Please ask for: Nicola Moore
Email: nicola.moore@arun.gov.uk
Telephone: Ext 37944
Our Ref: AW/130/22/HH
Your Ref:
Date: 9th June 2022

Application for Planning Permission for Works or Extension to a Dwelling

Development: Proposed rear balcony. Removal of pitched roof and replace with new flat roof.
Location: 37 Grosvenor Road Aldwick PO21 3EZ

Roof plan

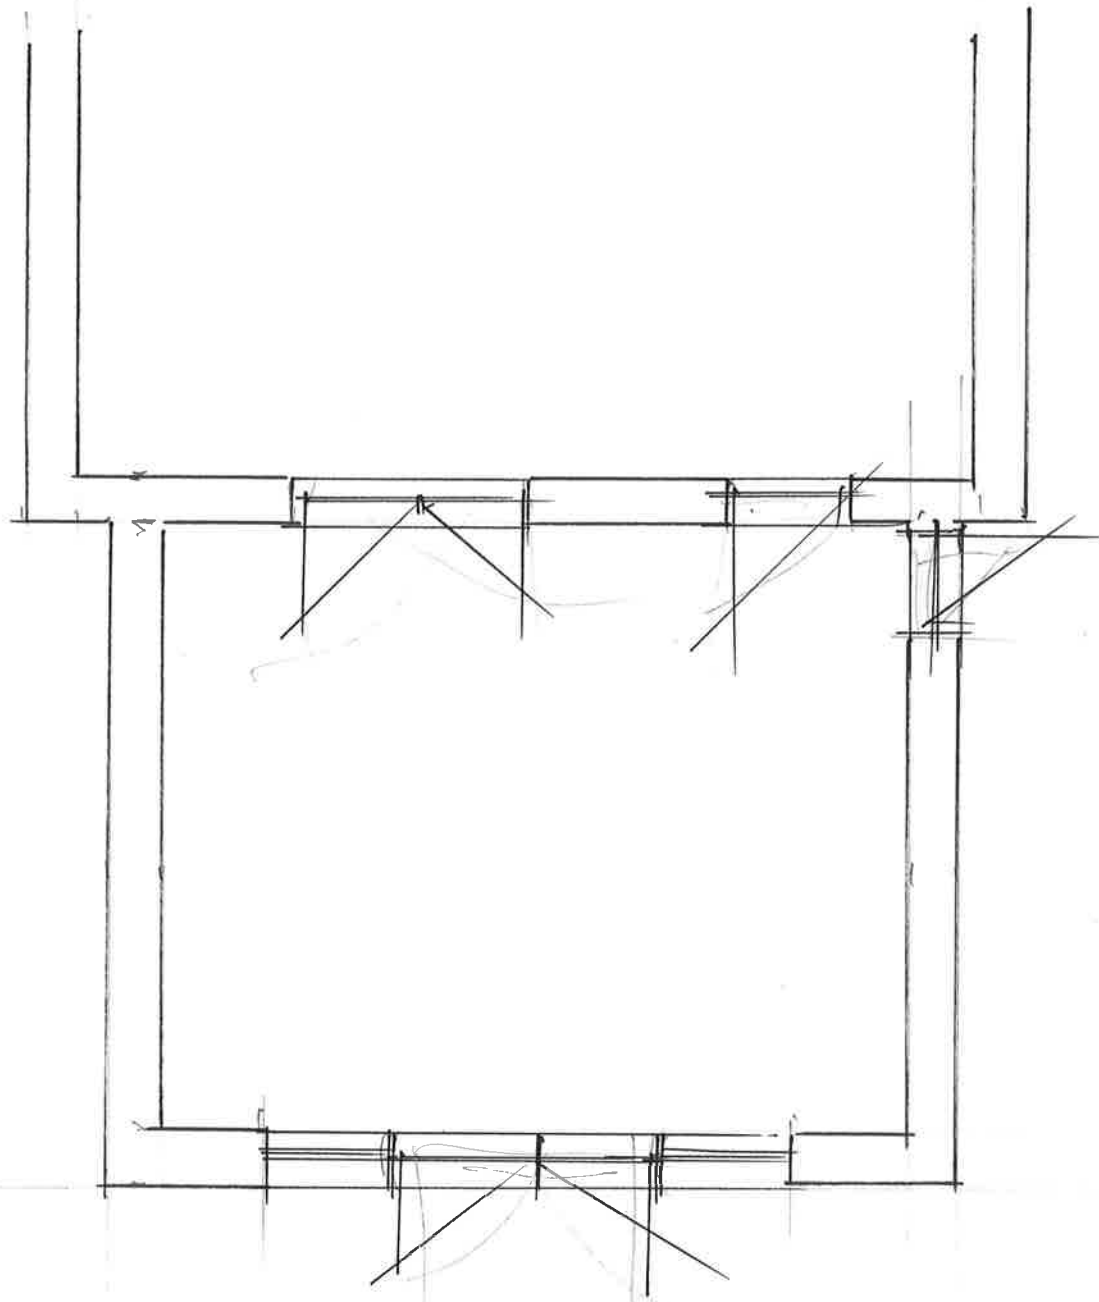
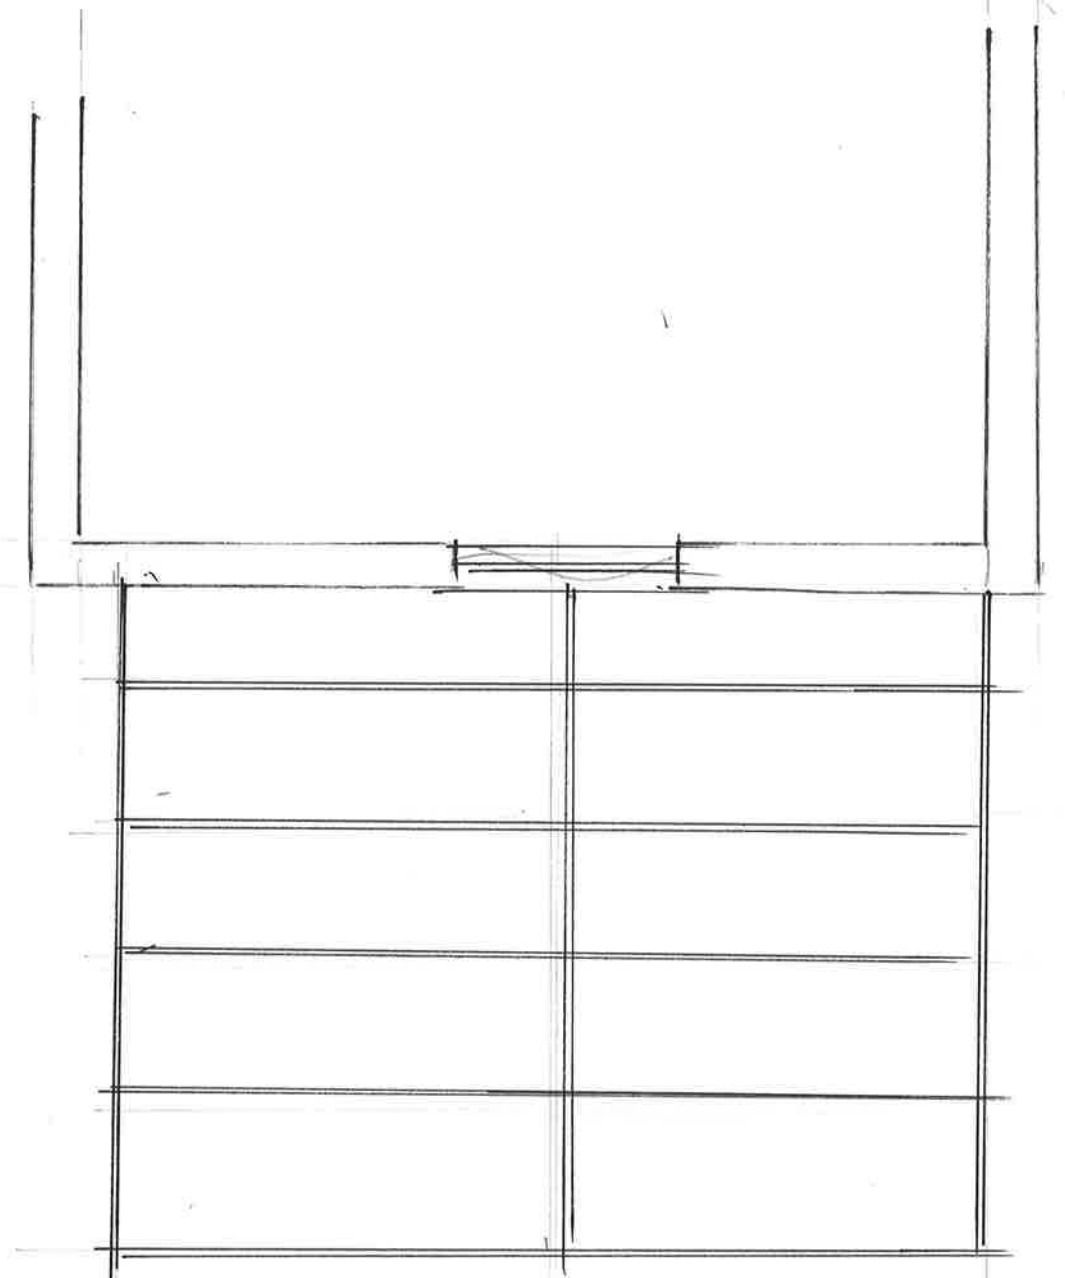
Roof Plan

Please submit electronic plans showing the existing and proposed roof plan. Please refer to the Validation Requirements List for further details.

AS EXISTING

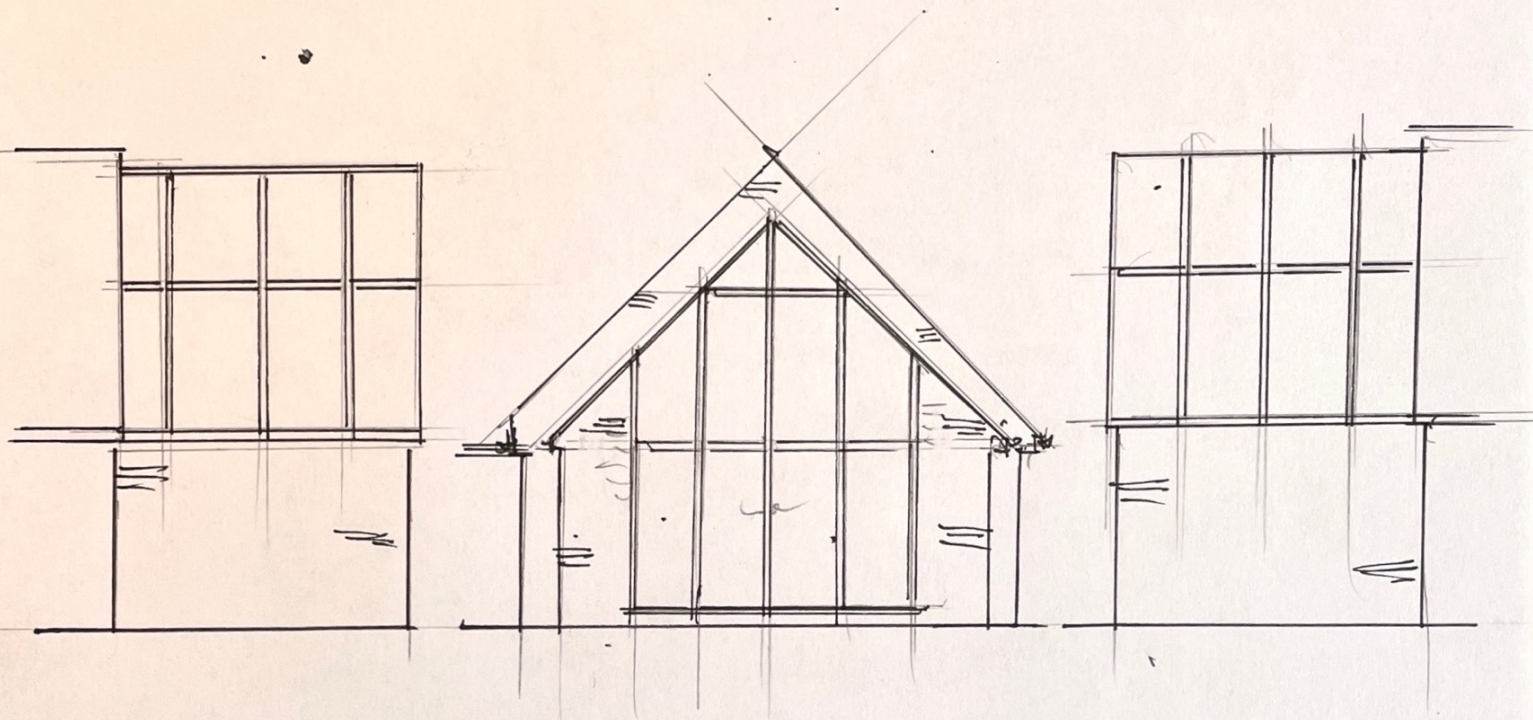
Please submit clearly labelled existing elevations.
